Engineers Comments Regarding Surface Water Drainage

Application Reference:	BN/34/26/PIP	Reviewer Reference:	ADC/EXT5/AF
Planning Officer:	Simon Davis	Date of Review:	25/03/2026
Site Name:	Land to the rear of Watermead Yapton Road Barnham PO22 0BQ		
Application Description:	Application for permission in principle for a minimum net gain of 2 dwelling to a maximum net gain of 3 No dwellings.		
Assessment Number:	1

Erection of up to 3 x self build dwellings; indicative plans for 2 x 2 bed and 1 x 4 bed.

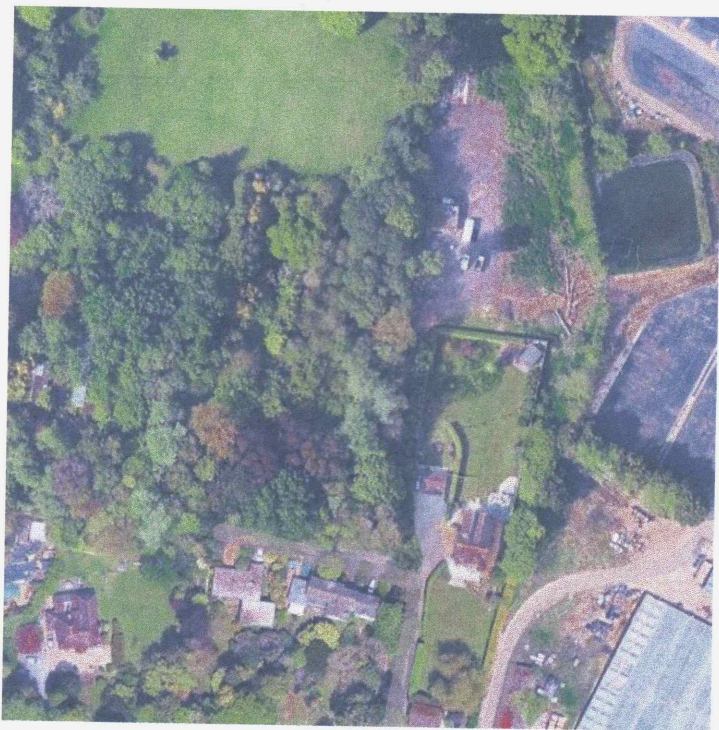
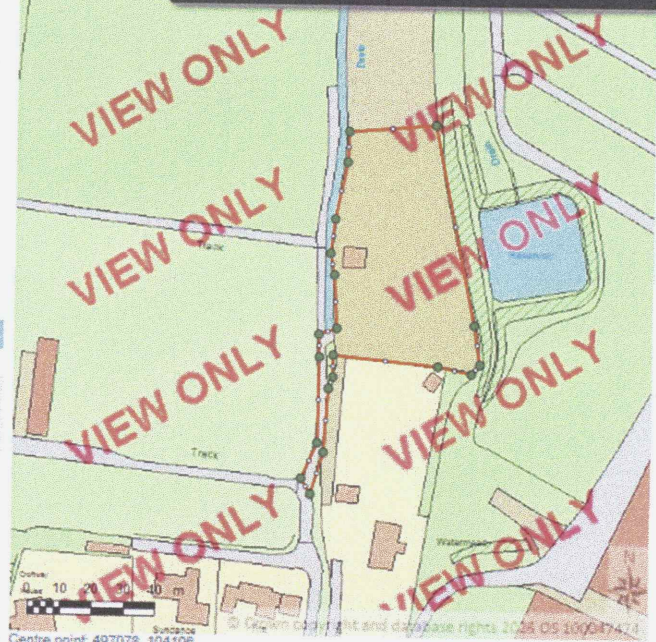
- 0.3. There is a local requirement to keep fences and structures at least 3 metres from top of banks of watercourses to ensure maintenance access is retained, this is not evident in the sketch plans and may constrain the site layout. We would object to the Technical Details Consent if this is not demonstrated in the proposed site layout.

- 0.4. There are some specific aspects of this site which would need to be addressed by the Technical Details submission and then controlled by planning conditions; 1) The existing culvert beneath the access road may require improvement, including the system immediately downstream, particularly if discharge to this system is proposed. 2) We are aware that a section of the eastern boundary ditch had previously been infilled, this should be investigated and if still the case, the watercourse will need to be reinstated to an appropriate standard as part of the development proposals.

- 1.1. No information has been provided with the application.
- 1.2. The runoff destination is not currently in accordance with the requirements of the NSfS. Therefore, we **object** to the application.
- 1.3. Groundwater is known to be shallow at this location and infiltration is unlikely to be viable. The feasibility of discharge to watercourse or sewer should be demonstrated to establish the principle of development.
